Subject: F/14/24/RES - Ford Airfield IRM ADC Drainage Consultation 2

Engineers Comments Regarding Surface Water Drainage

Application Reference:	F/14/24/RES	Reviewer Reference:	ADC/SB
Planning Officer:	Jessica Riches	Date of Review:	30/07/2025
Site Name:	Land at Ford Airfield Ford		
Application Description:	<p>Approval of reserved matters (layout, scale, appearance and landscaping) following outline consent F/4/20/OUT for the infrastructure reserved matters including the provision of a primary spine road and associated secondary road junctions, pavement, footpaths, cycle infrastructure and bus stops; site wide drainage infrastructure including foul pumping stations, foul sewer infrastructure, SUDS basins, SUDS swales, surface water infrastructure; acoustic fencing; public open space including landscape details, play areas, footpaths & associated works. This application affects a Public Right of Way, may affect the setting of a Listed Building and falls within CIL Zone 1 (Ford strategic site - zero rated).</p>

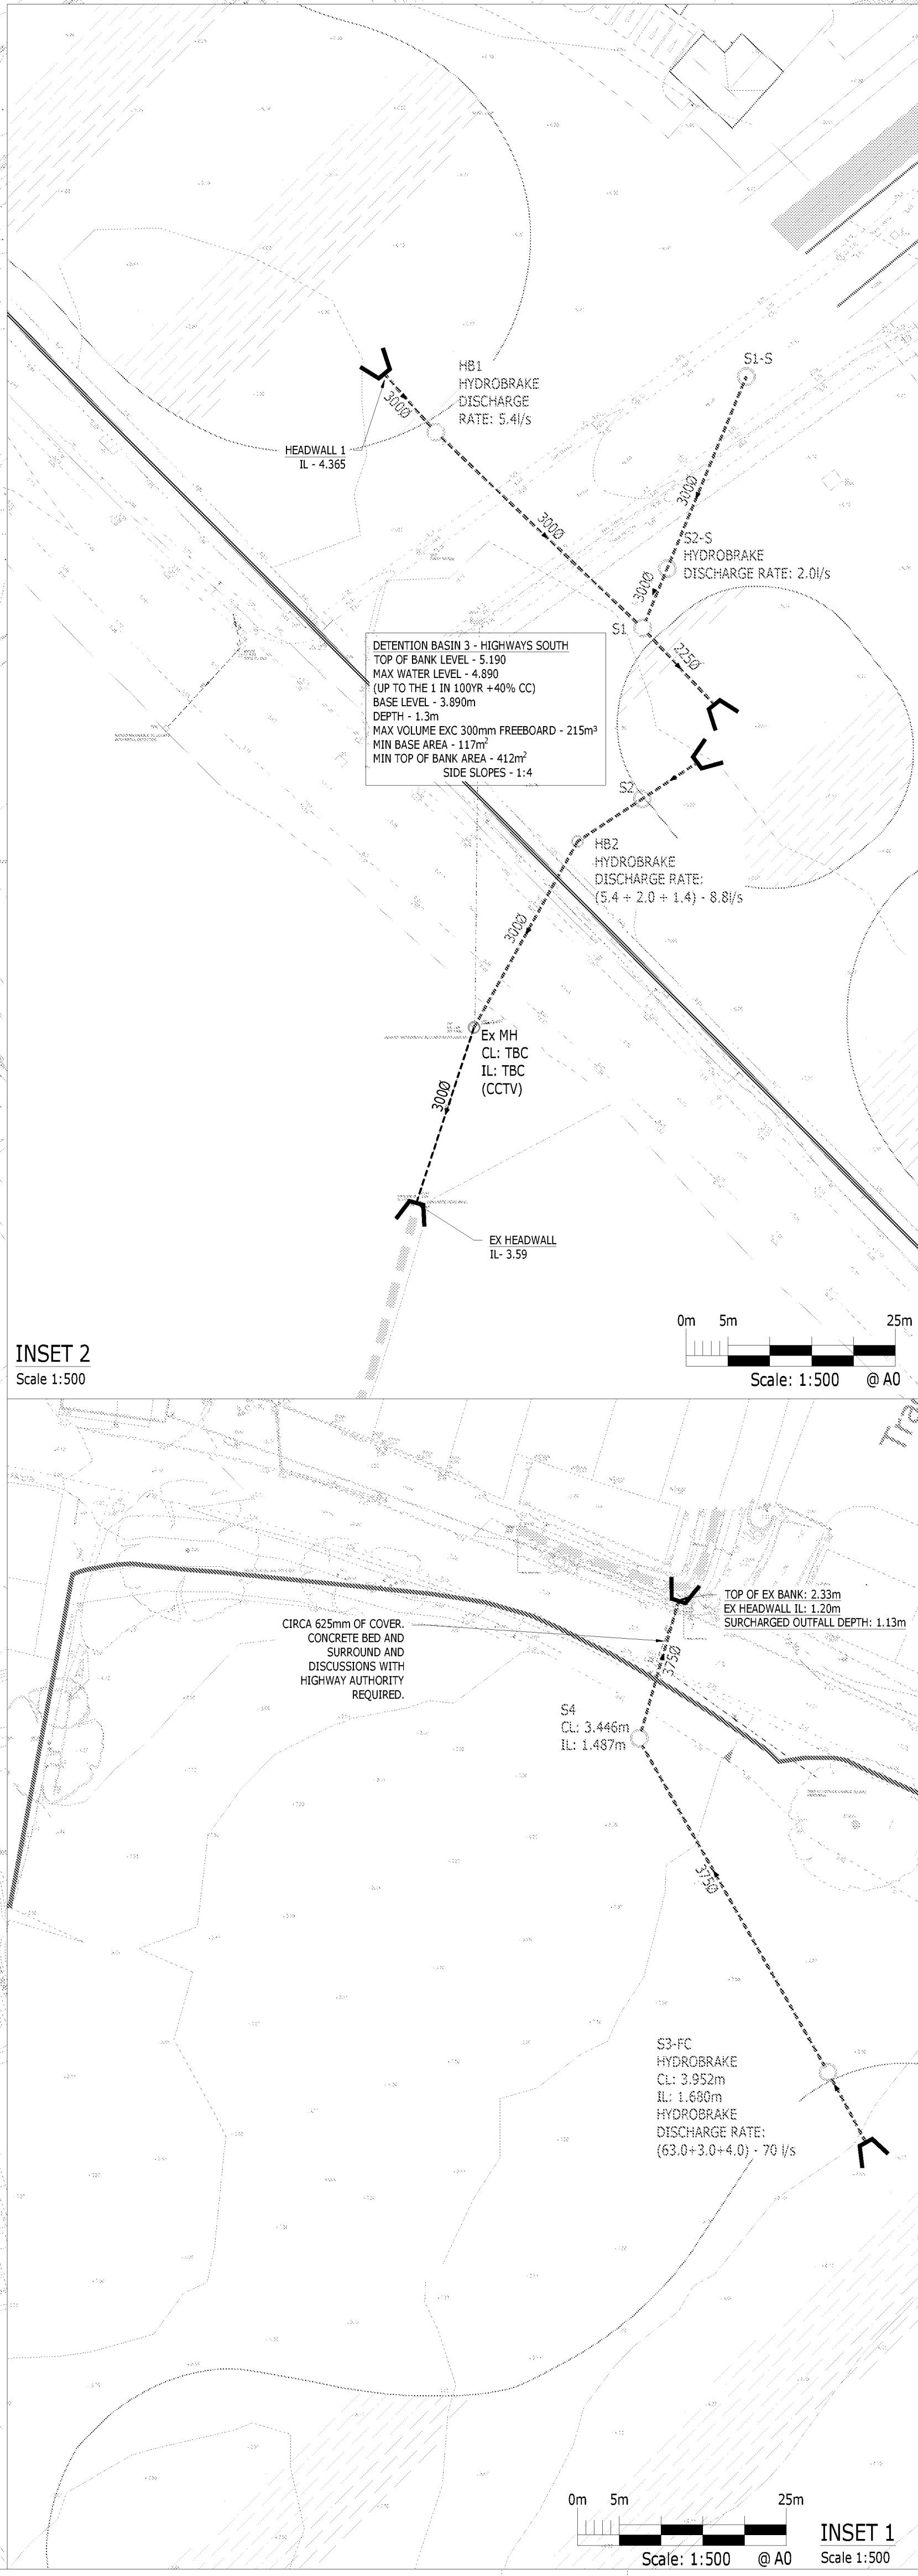
Irrespective of whether the airfield drainage can and should be used, it is not acknowledged or protected. The ExAF Network is not shown on any of the site plans and nor has it been considered a constraint to the development of the layout of the site. The status and condition of the network is unknown, and it is unclear whether the network has a legal right to protection via our Land Drainage Byelaws. An easement of 3m either side of the edge of the culverts may be necessary. The onus is on the applicant to demonstrate that this network is not a constraint to the wider site layout which affects the infrastructure layout.

The contributing areas for the design calculations (for the size of the storage in the systems) are still unclear. The impermeable area plans for this submission do not include all of the access roads that are within the red line boundary, nor the contributing area of the basins themselves. In addition, the contributing area plans for phases where the proposed layout is known, have not been submitted. Using these would give a more accurate representation of the contributing areas.

The modelled areas for all three catchments are significantly different between the ISW Plan and DSR Appendix F. This is illustrated in the table below. It is understood that the ISW Plan uses contributing areas based on an assumed 60% impermeable area with urban creep applied. These contributing areas are likely to be a cautious estimate, as they should be, given the uncertainty at this stage. There is insufficient justification for the change in contributing areas between the ISW Plan and the models.
